Project Name: WAGGOMAN-DENISON ADDITION

DRB Comments

PROJECT # 1007449

RE: Lots 13-18, Block 1, Waggoman-Denison Addition

VICINITY MAP
ZONE PAGE K-20-Z

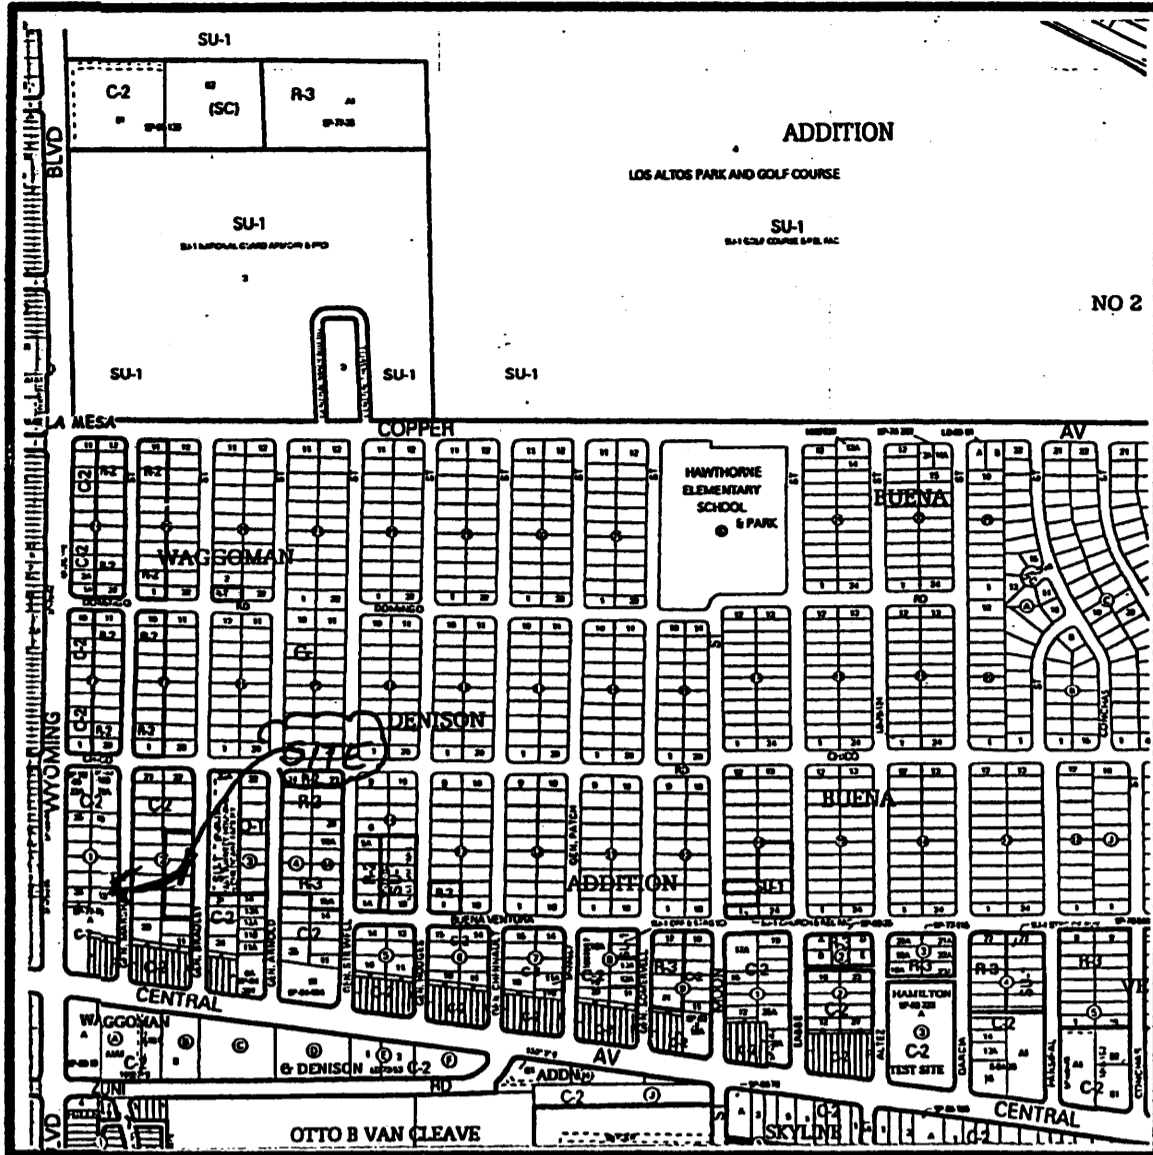
The Vicinity Map on the plat needs to be corrected – it is currently identifying the wrong block.
